Application Reference: 2026/0035

Site Address: 1 Cherry Trees, High Hoyland Lane, High Hoyland, Barnsley, S75 4BG

This application seeks full planning permission for the erection of first floor side and single storey front extensions, and alterations to front porch of dwelling.

1 PROPOSED FRONT ELEVATION
SCALE: 1:100

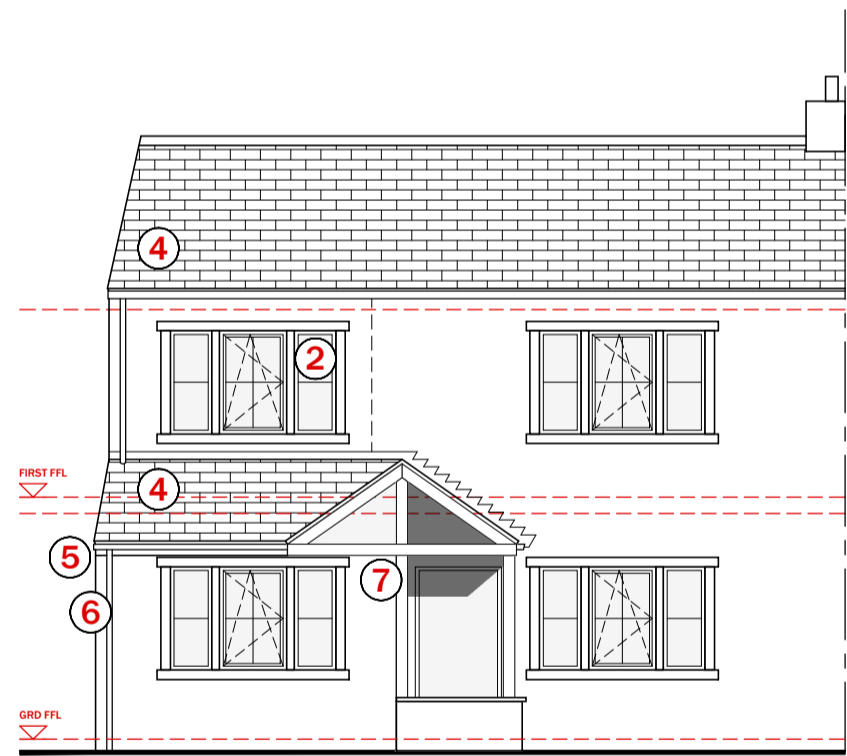
The existing front facing porch is a modern glazed structure of little merit. To the front of 2 Cherry Trees there is also a glazed porch and to the rear there is a pitched roof extension with a ridge / Application No 2026/0035 Proposal 2026 0035 Erection of First Floor Side and valley in line with the main ridge. The application details the replacement of the front porch (1 Cherry Trees) with a stone-built structure that includes a stone monopitch roof and a small timber(oak) framed porch to the side. The replacement front extension increases the useable space of the kitchen into to an open plan diner. Externally, I feel this is an improvement, removing a feature that detracts, with an appropriate design and in sympathetic materials. The existing ground floor lean-to on the gable is characteristic as a form. However, extending over this to include extra first floor space by extending the ridge of the main house body is not untypical (historically) or out of keeping with the conservation area. The existing narrow chimney stack on the gable is

- The facing stone to the proposed development shall match the existing building in terms of its colour, general grain size, type of face dressing, and method of coursing.
- The pointing proposed to be carried out in connection with the development shall be in rich lime mortar, flush to the face of the stone and finished by brushing off to produce a very slightly recessed and rounded joint.
- The roof covering shall be natural stone slate laid in diminishing courses to match the existing.
- All rainwater goods shall be black, and gutters shall be ogee in section.
- Windows shall be white and mounted in the reveal a minimum of 100mm.

2 PROPOSED GABLE ELEVATION
SCALE: 1:100

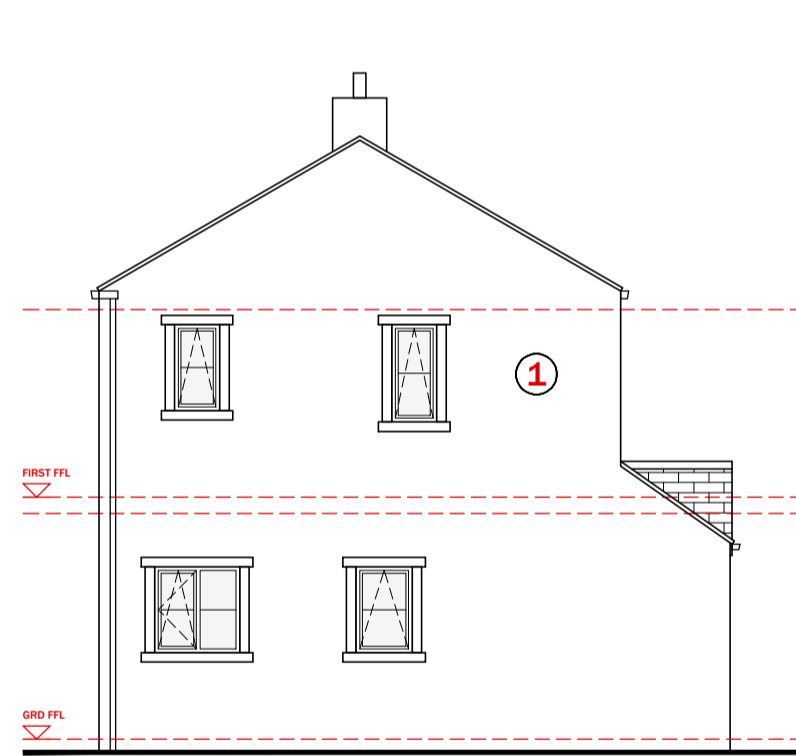
This application requests approval to replace the front porch and build a two-storey side extension. The project will extend the current ridge line southward, covering the area where a ground floor lean-to is attached to the gable. The property lies within the High Hoyland Conservation Area, on elevated ground behind and north of The Cherry Tree PH. It appears on the first edition six-inch Ordnance Survey from 1849-50 (see below), and likely dates from the mid to late 19th century. Built from coursed stone with stone roofing slates (used on 1 and 2 Cherry Trees—Blacksmiths Cottage uses concrete pantiles), the terrace features mullioned windows with later casements on both floors. There are two chimneys: one on the gable end and another shared with number 2, both topped with terracotta pots. The ground floor currently includes a later lean-to extension housing the kitchen and a downstairs bathroom. Given its historic significance and appearance, these cottages make a positive contribution to the character and group value of the wider conservation area.

later and in brick and render. Broadly speaking, stacks in conservation areas add historic character to the skyline and the roofscape. However, in this case the stack is clearly later and of a different design and materials to the shared stone (later rendered) stacks on the rest of the roof. As such, the loss of the gable stack will have a minor impact and, in my view, will not be harmful. Overall, there would be little harm in the proposal, that will improve the appearance of the dwelling (individually) and maintain the positive contribution to the group value of the conservation area.
